CITY OF ALBUQUERQUE

July 15, 2024

Re: Fire Station #4
301 McKnight NW
Conceptual Traffic Circulation Layout for DFT Approval
Engineer's Stamp 07-10-24 (H14D120)

**B1** **TRAFFIC SIGNS**  
Scale: 1" = 1'-0"

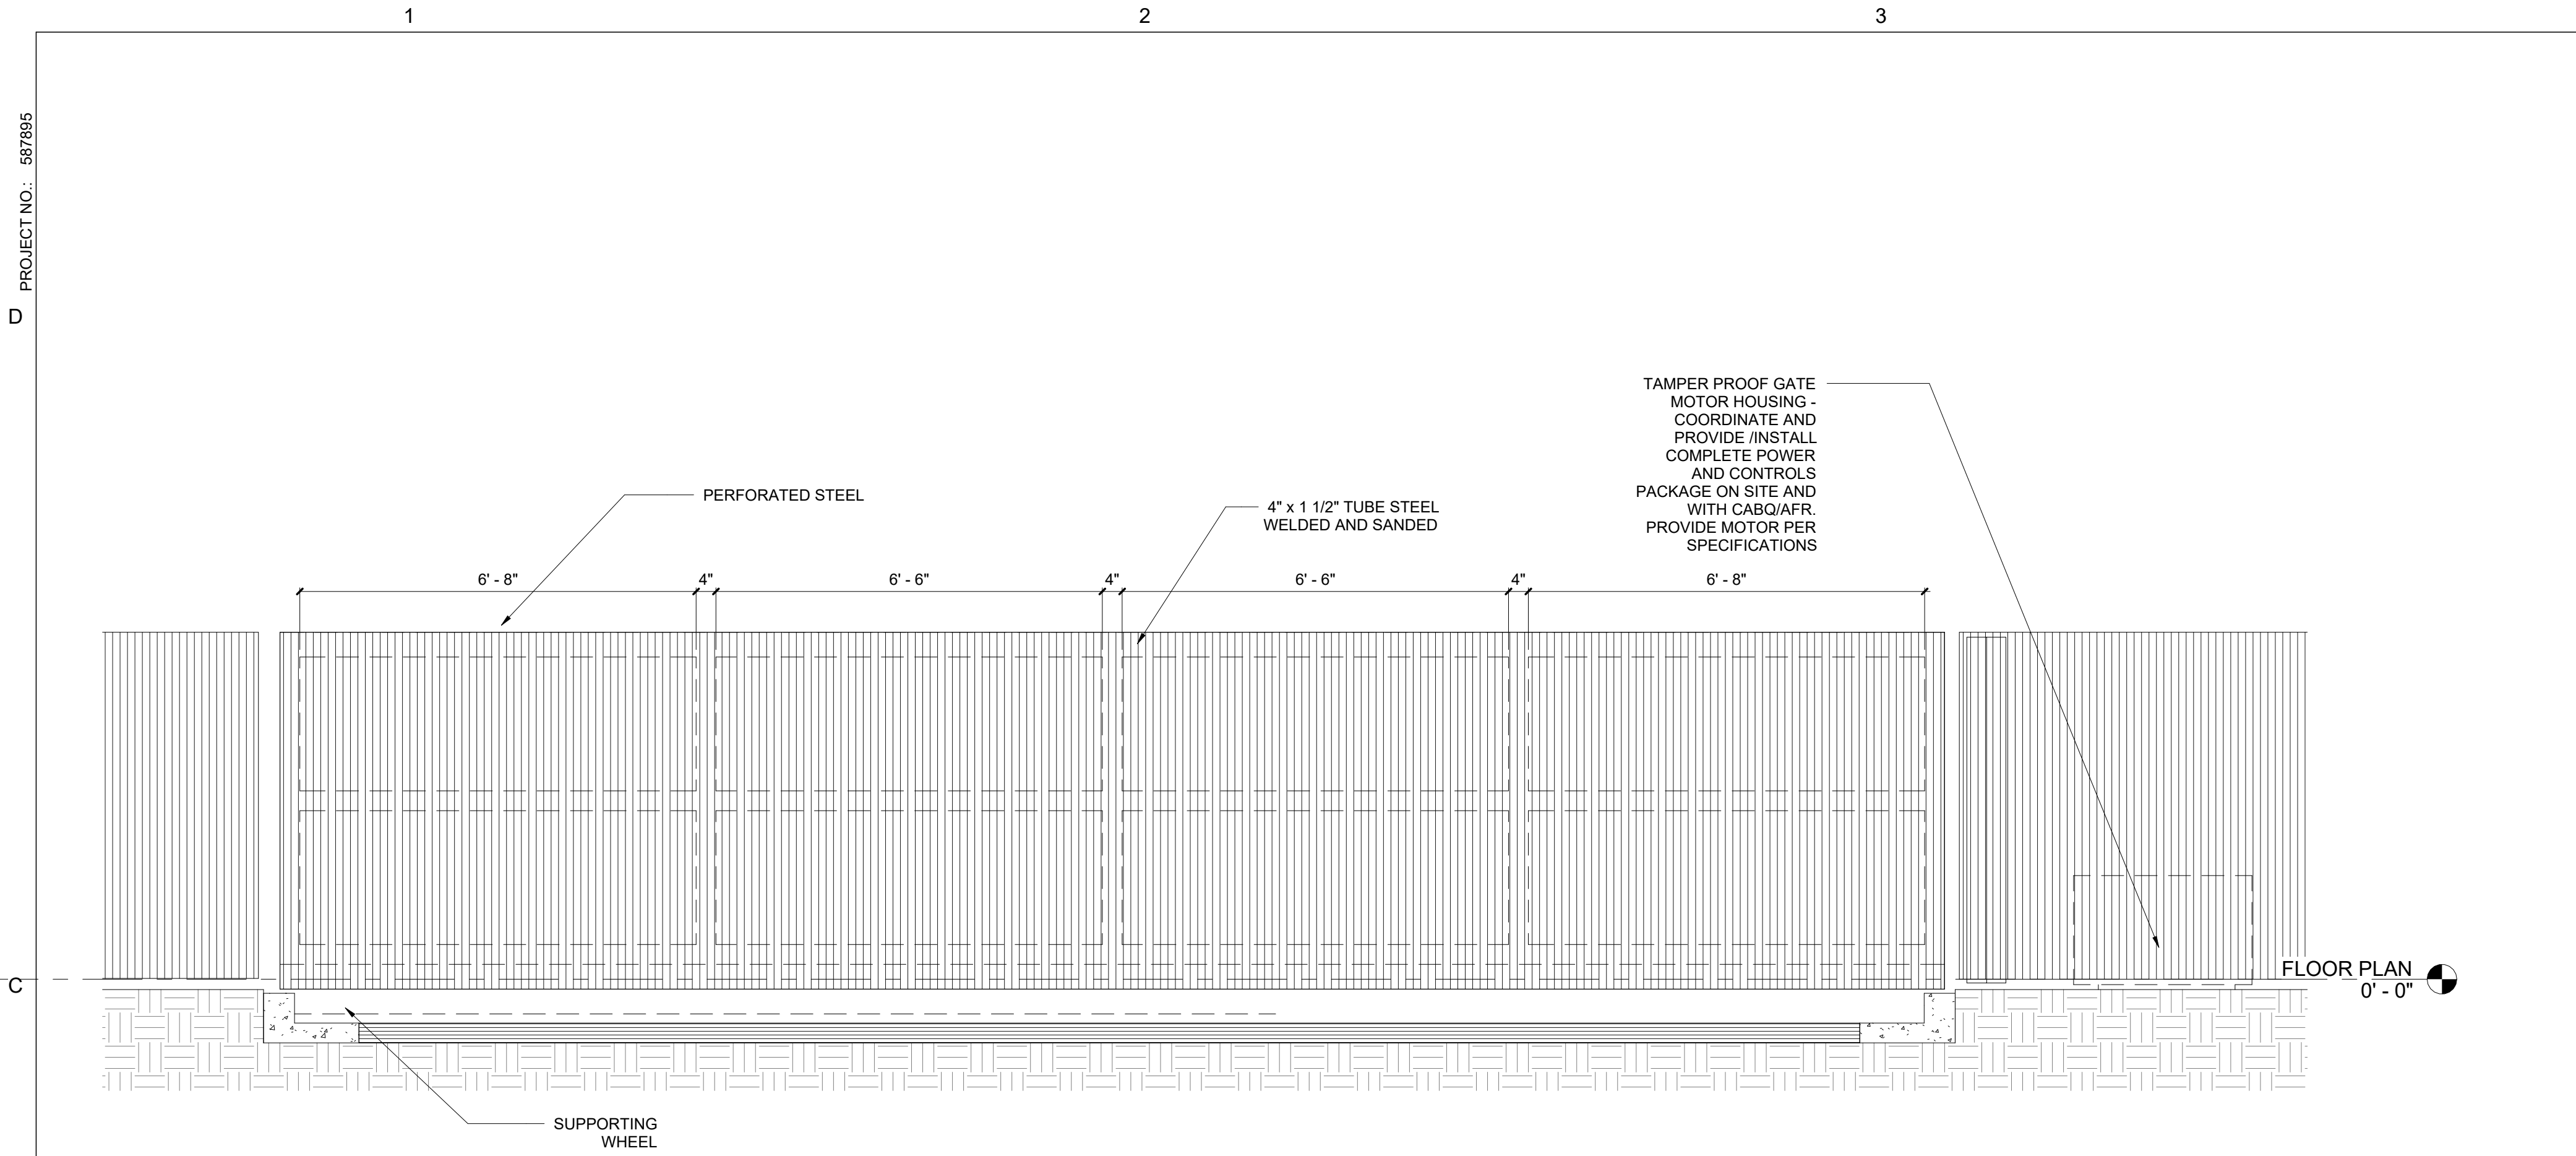
3-Install sign for the Motorcycles parking

4-All one-way drives shall have "One Way" and "Do Not Enter" signage and pavement markings. Please show detail and location of posted signs and striping.

B3 BIKE RACK
Scale: 3/4" = 1'-0"

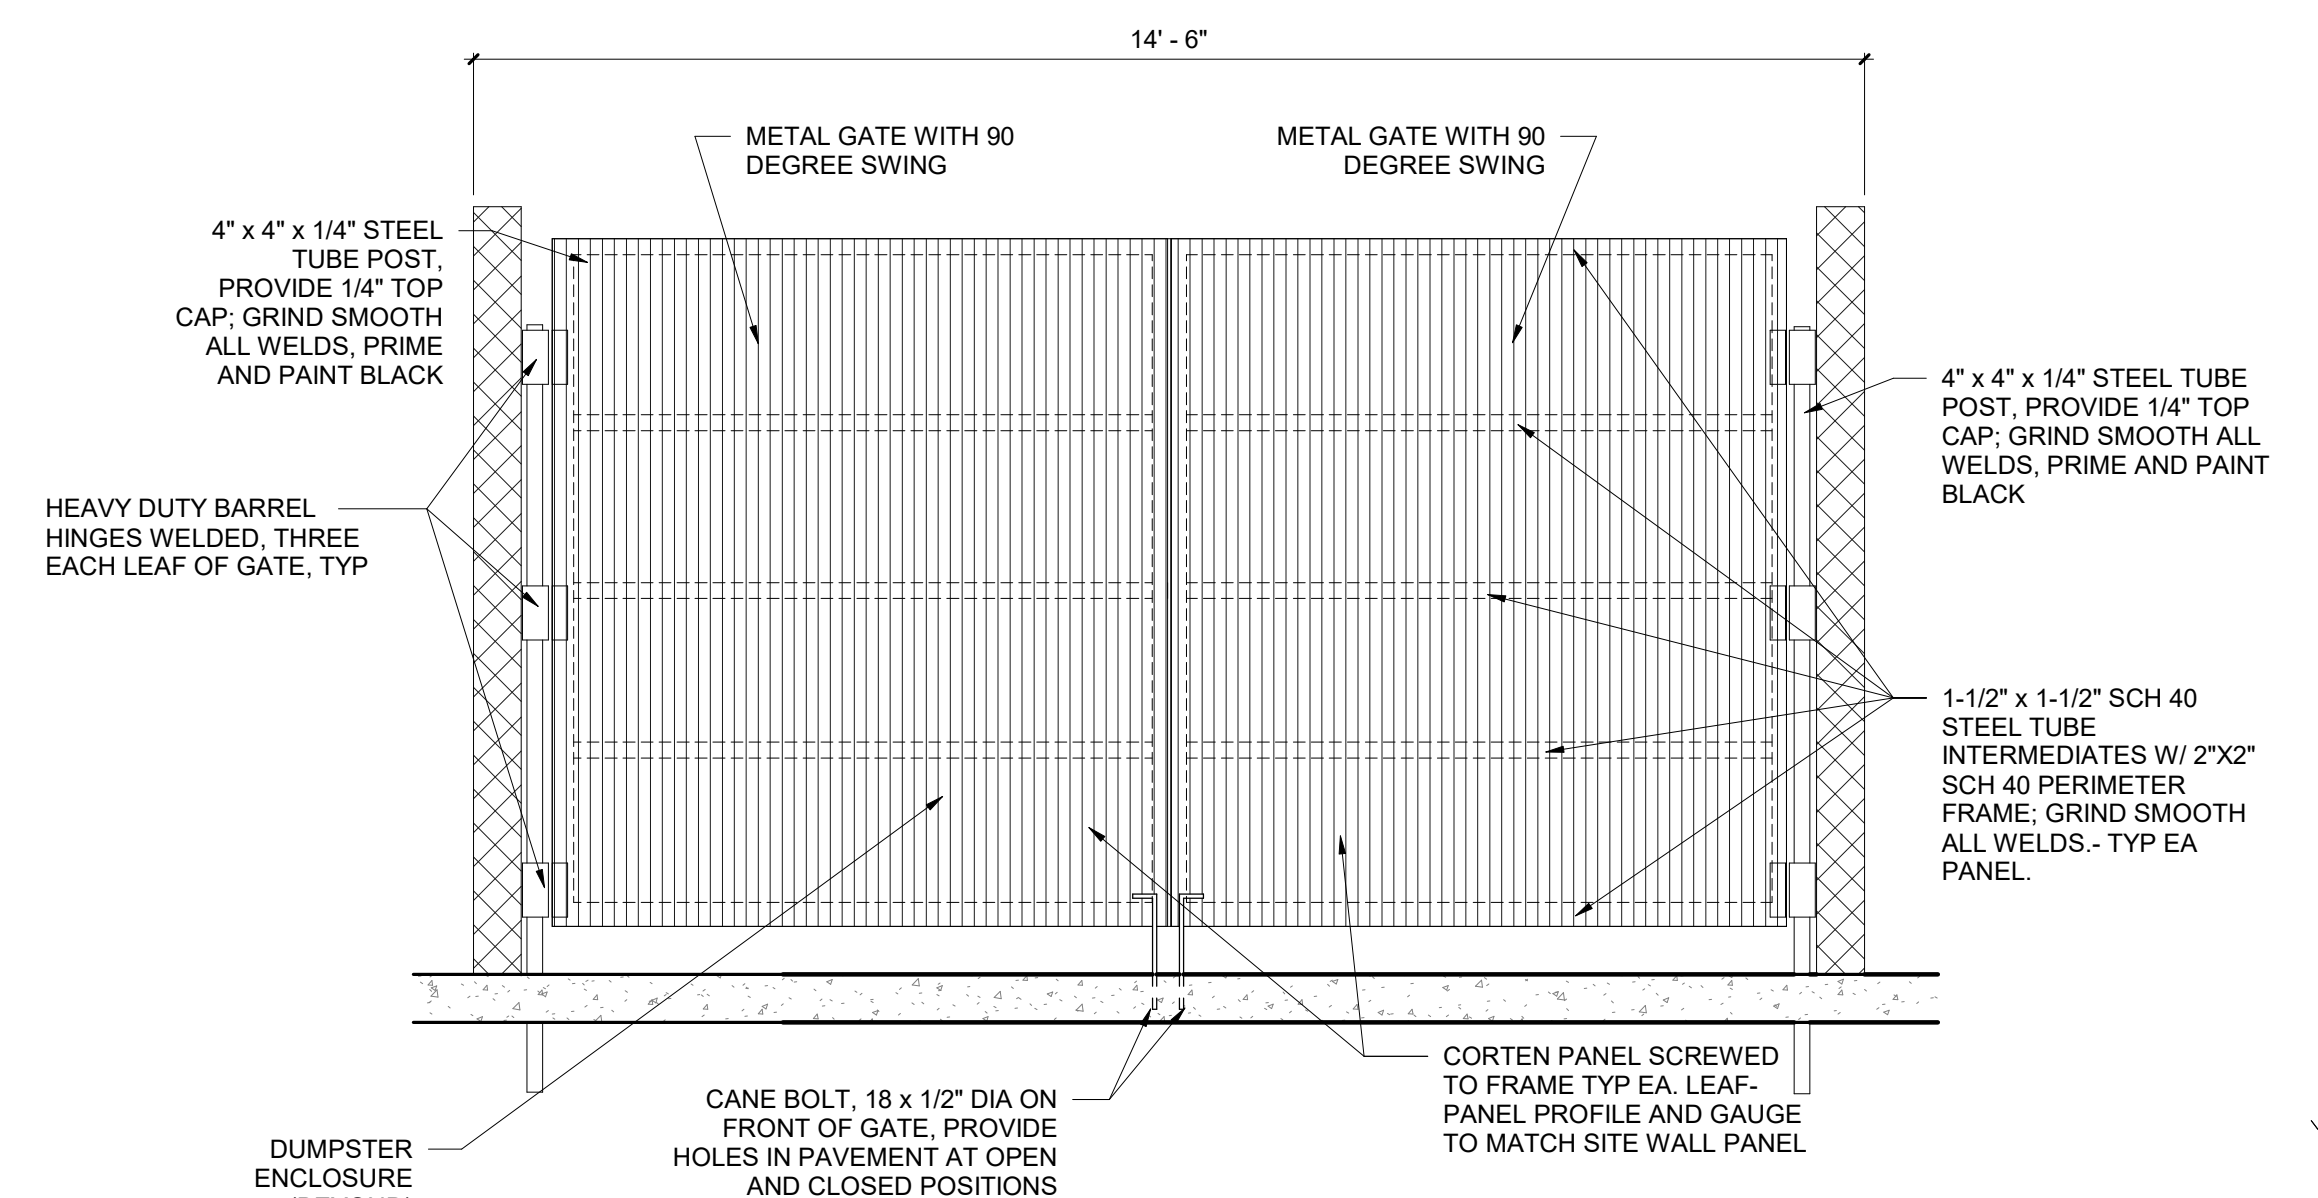
1-Replace the Bike Rack type with the a type that is approved by DPM.

2-Bike Racks should be on paved base.
